From: Nicholas Najar <NicholasNa@ryde.nsw.gov.au>
Sent: Tuesday, 24 October 2023 1:55 PM
To: Judith Elijah
Cc: Sandra Bailey; SanjuR; Lashta Haidari
Subject: Request for Extension of Time - Council Submission on 39 Delhi Road - SSD-55844212 - COR2023/91

Council understands the submission for the 39 Delhi Road, Build to Rent SSD Proposal (SSD-55844212) was due on the 22/10/23 however due to the significant amount of SSD's (9) Council is reviewing, Council is unable to make the submission date. As such Council requests an extension of time to the **4th of December 2023.**

Figure 3 – Plan of basement level of proposed development  
Source: Koichi Takada Architects

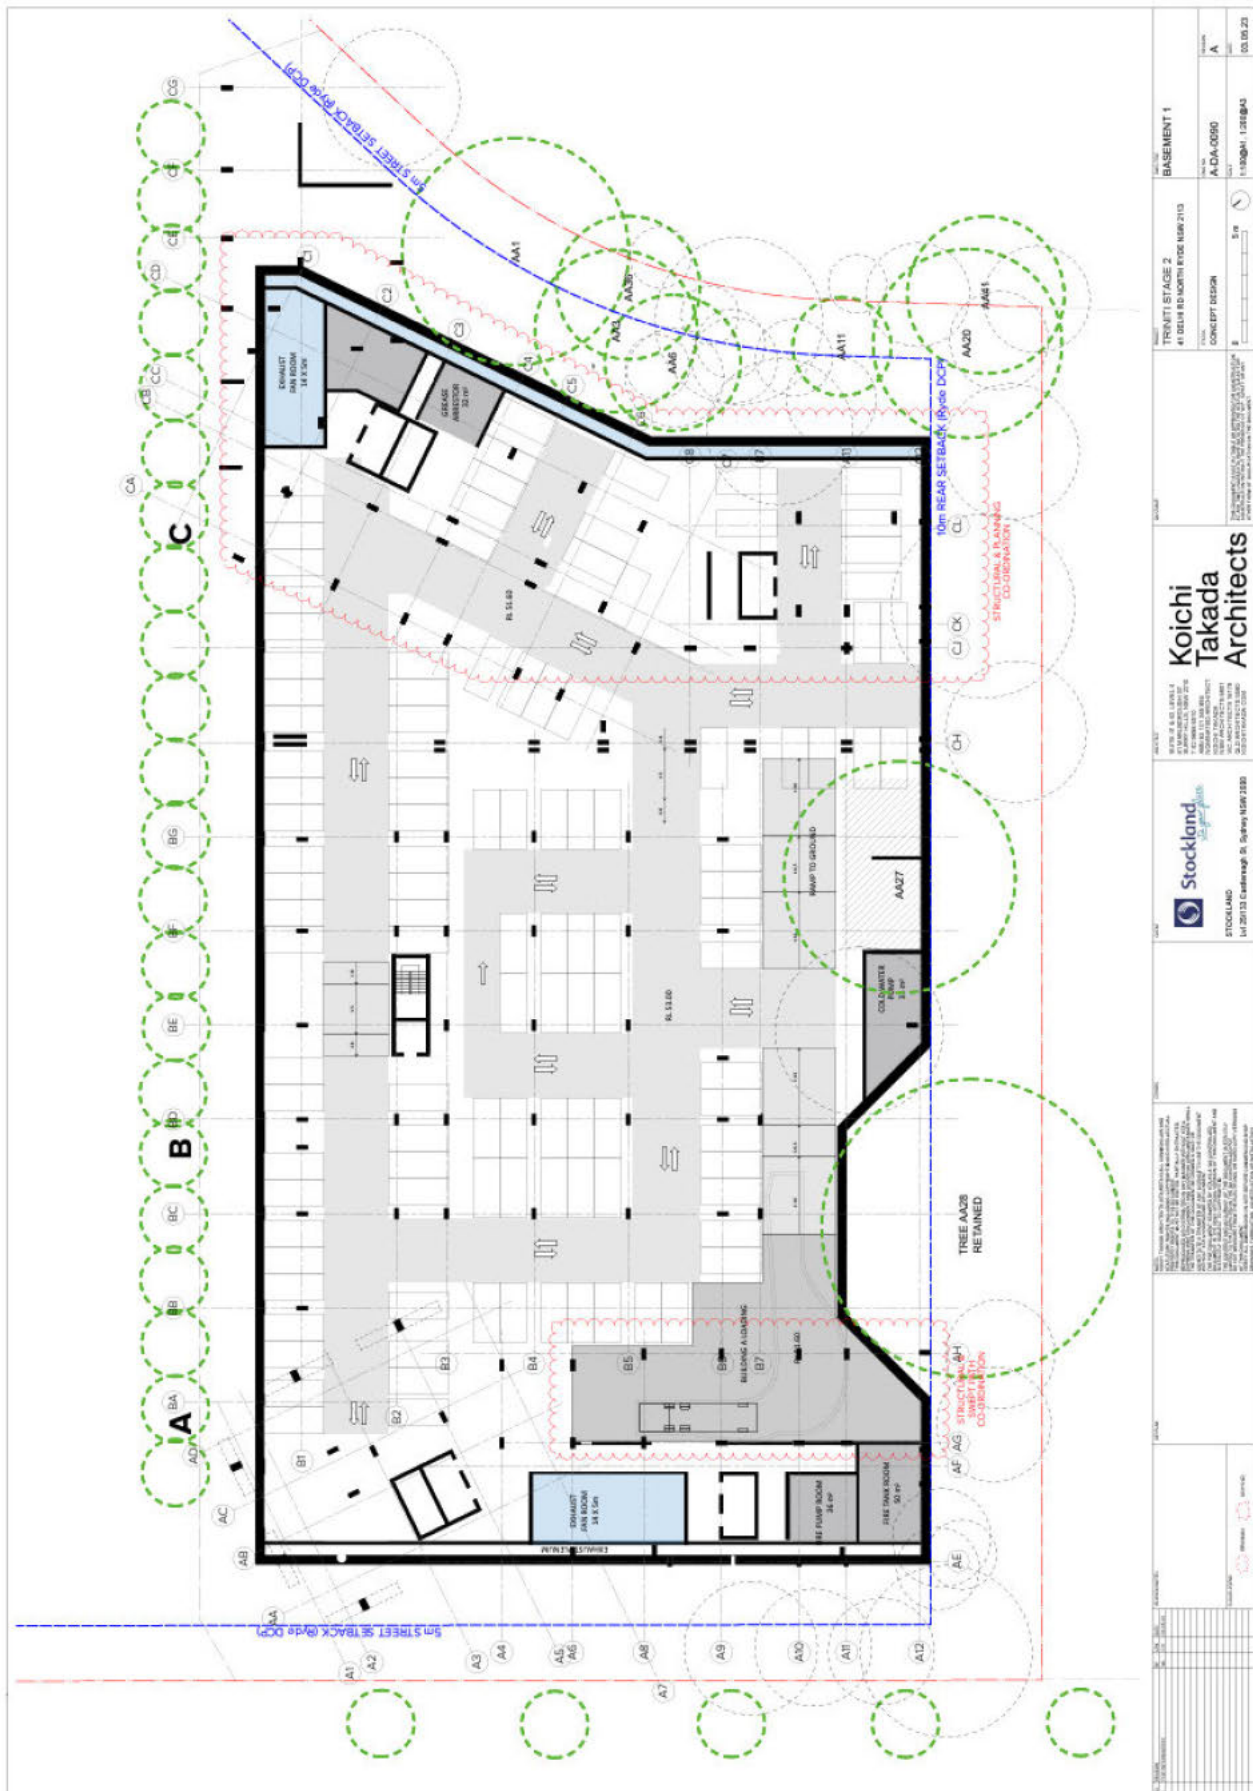
- b. Council is unsupportive of the non-compliant basement setbacks, within the 10m area.
- 3) **Strategic Planning** – At a high level Council is unsupportive of the scheme from a strategic perspective in its current form, as:
